FINAL
DRAINAGE PLAN AND REPORT

**8140 and 8150
CESSNA DRIVE**

**PROPOSED AIRPORT HANGER
LOT 7 BLOCK 1
MEADOW LAKE AIRPORT
FILING NO. 2**

County Fil No.: PPR2138

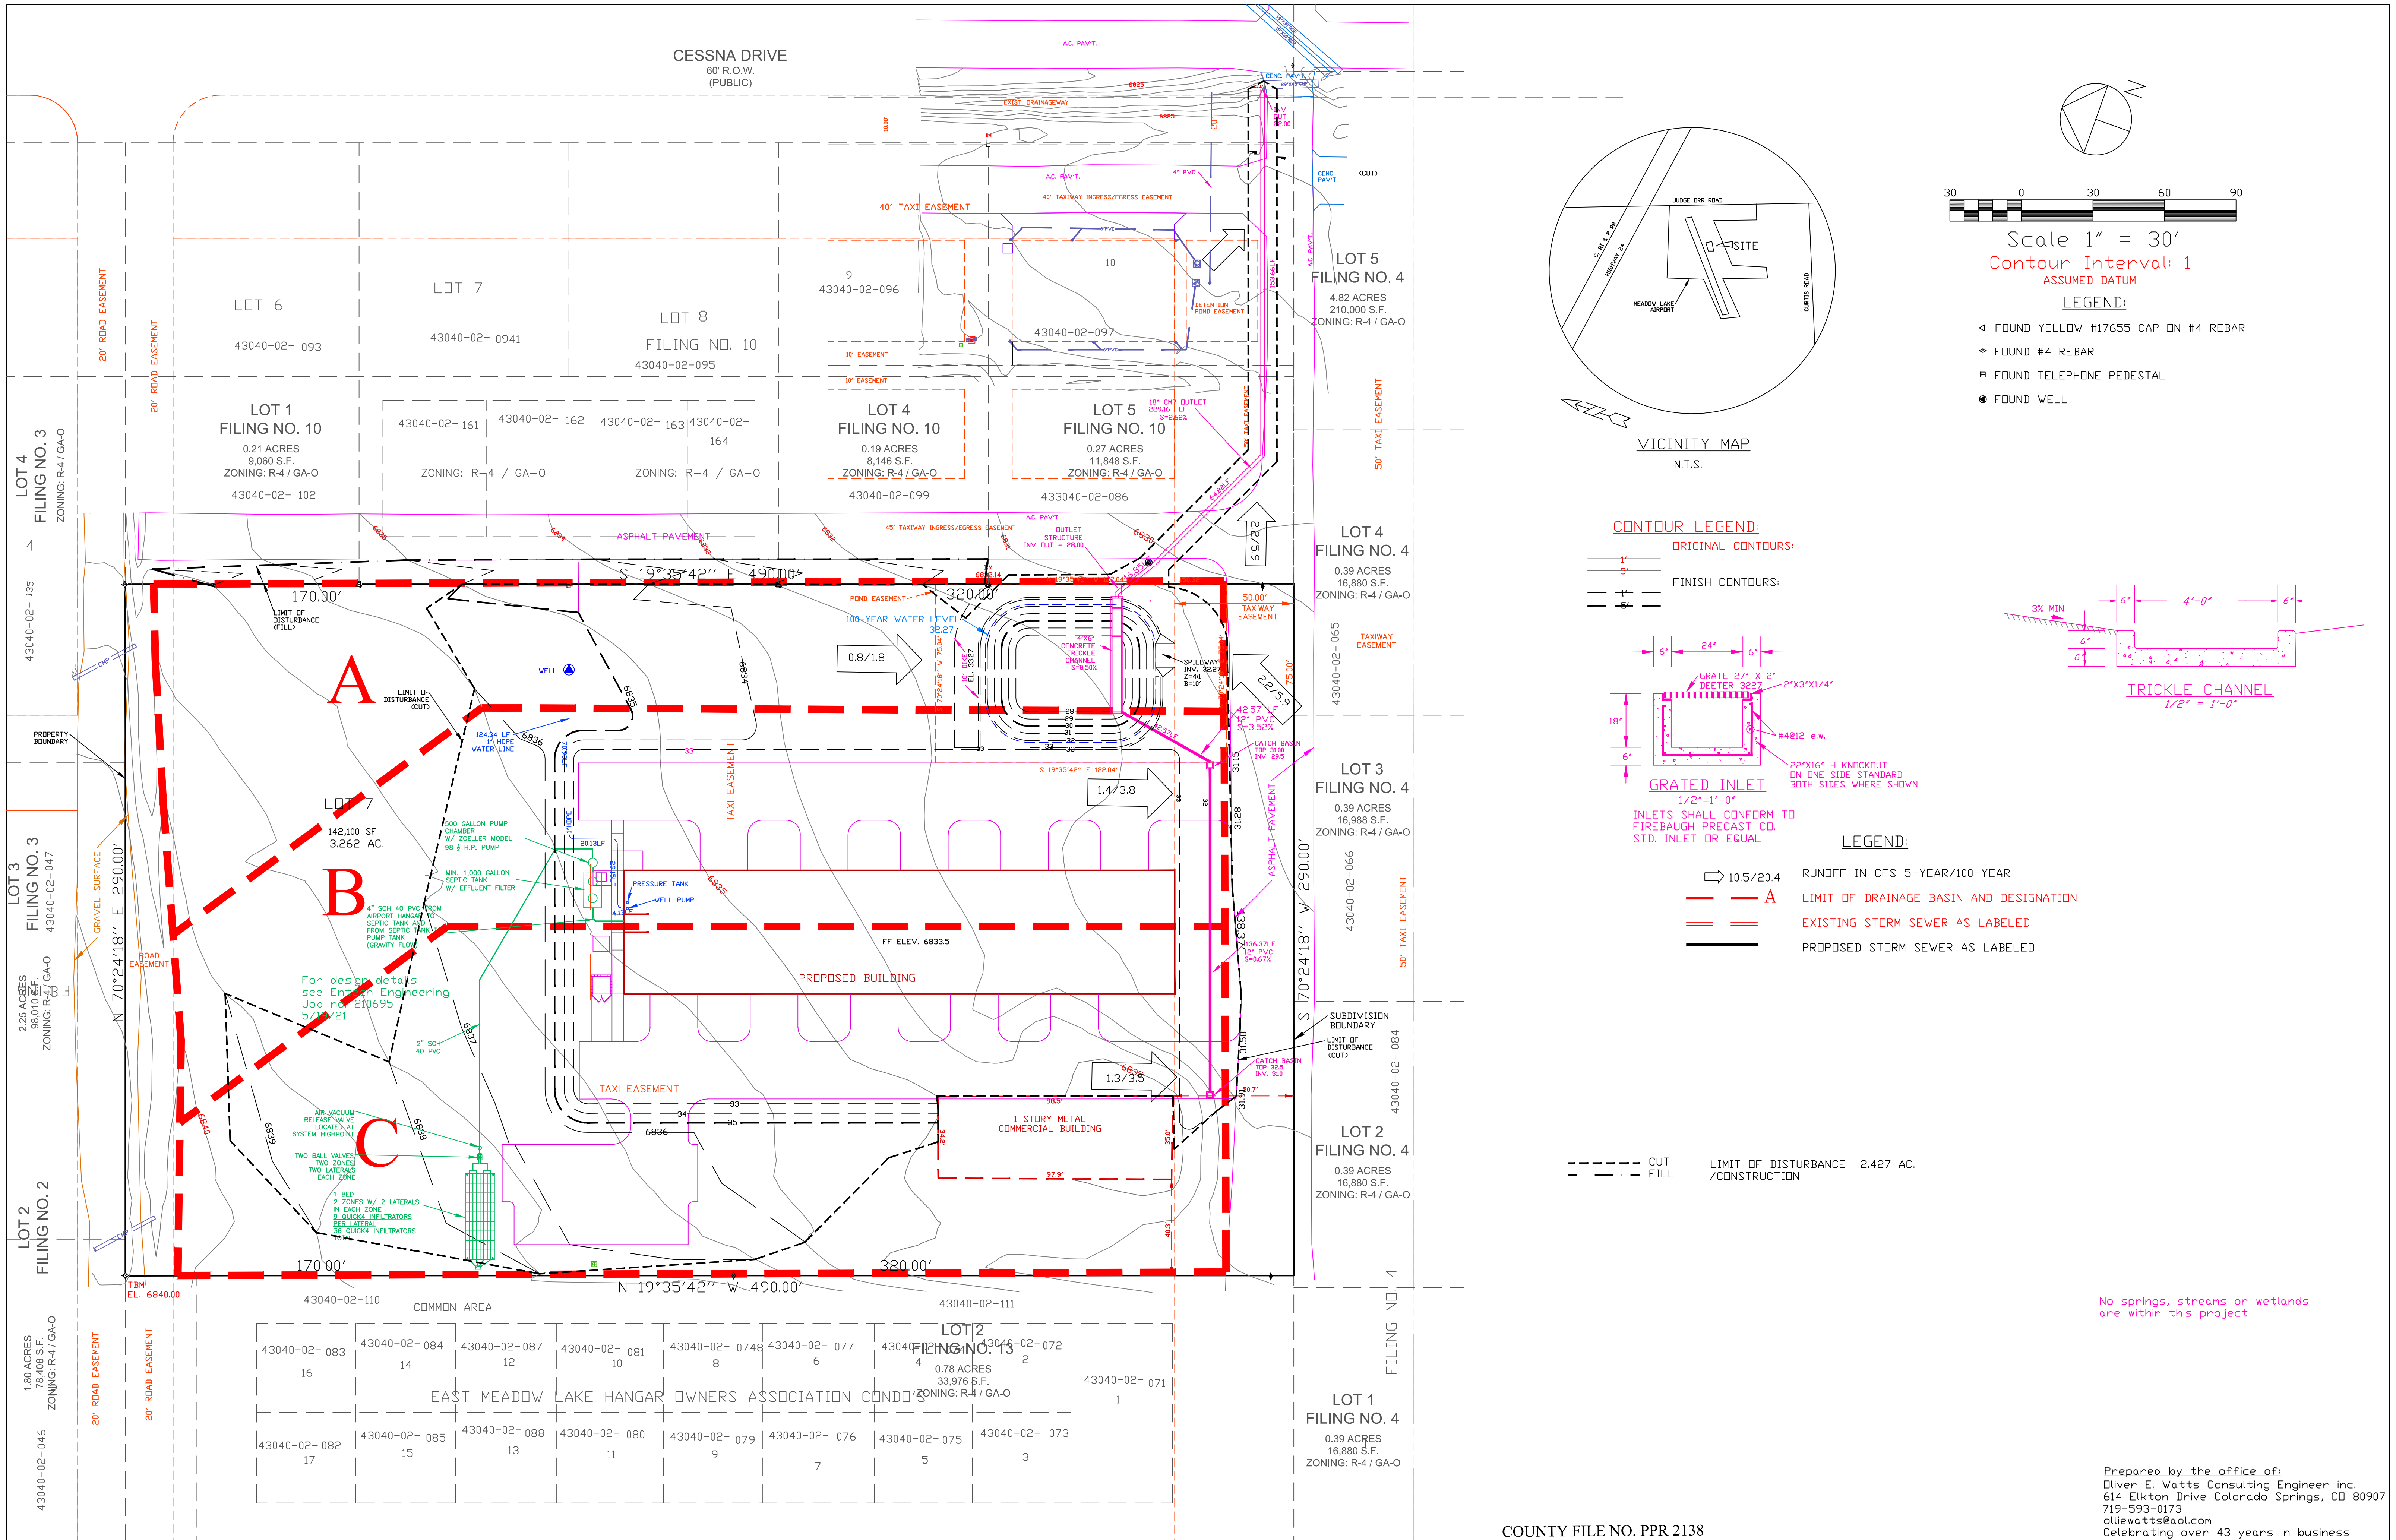
Please describe what water quality is being required for. Is it only for the one hangar that is being proposed now? Please address water quality for the future hangars.

Please include calculations to include the future hangars impervious areas since pond will have to be retrofitted in the future in another site development plan.

Please include impervious amounts for future hangars that are shown in the site development plan, it appears that it is more than 50%.
